Consultation Response from KC, Trees
2023/91441 31, Chapel Hill, Linthwaite, Huddersfield, HD7 5NJ
Change of use and alterations to former church (B8-storage) to 9 residential units (C3) and formation of car park (Listed Building within a Conservation Area)
Date Responded: 17/04/2025 Responding Officer: JD Responding Ref: 03/82

Drawing:  
 Proposed  
 Site Sections

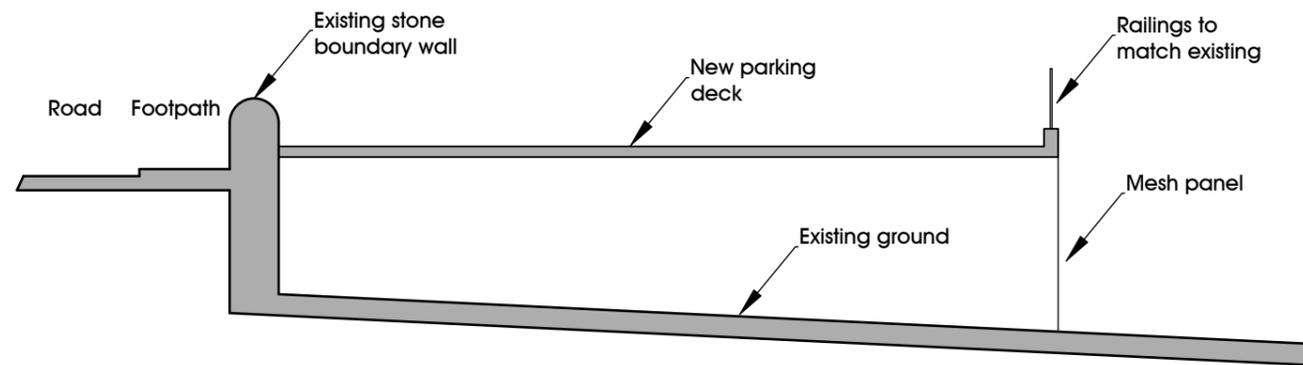
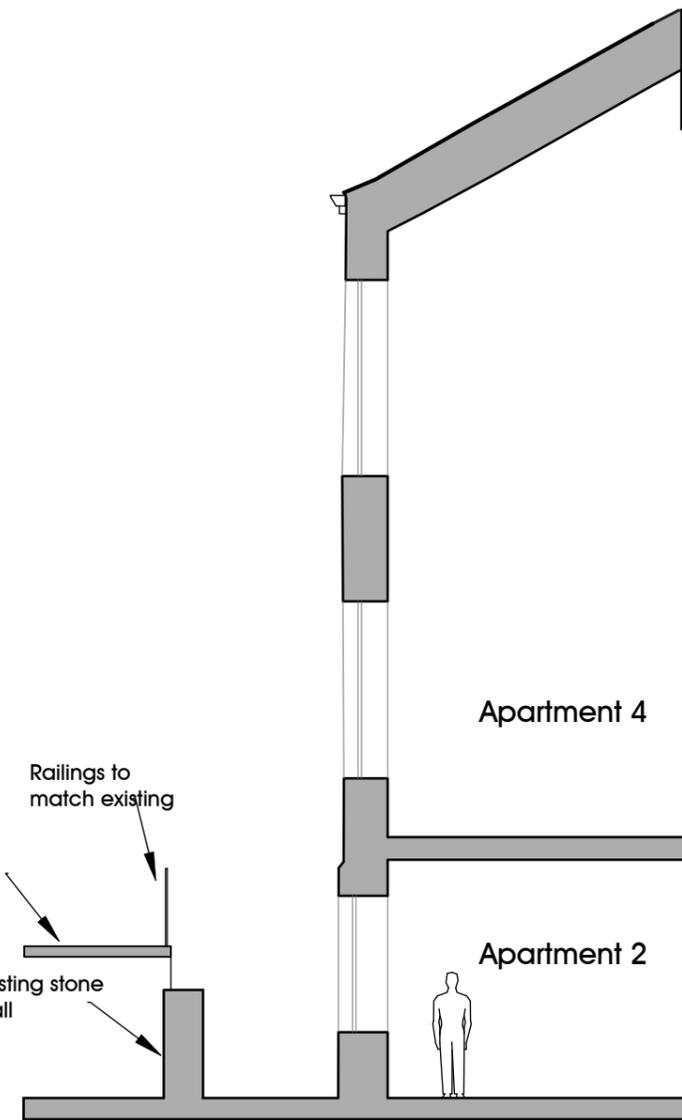
The newly submitted plans now correspond and show the specialised foundations will be used within the RPA's of T6 and T7. The submitted AIA sufficiently details the steps that will be taken to ensure there is no impact on the adjacent trees.

Now an Arboricultural Method Statement would be required to show how the tree protection elements will be implemented in this project but this can be done via condition.

Notwithstanding the submitted plans and information, an Arboricultural Method Statement, in accordance with British BS 5837, shall be submitted and approved in writing by the Local Planning Authority before construction commences. The method statement shall include details on how the construction work will be undertaken to minimise damage to the retained trees. Thereafter, the development shall be carried out in complete accordance with the Arboricultural Method Statement.
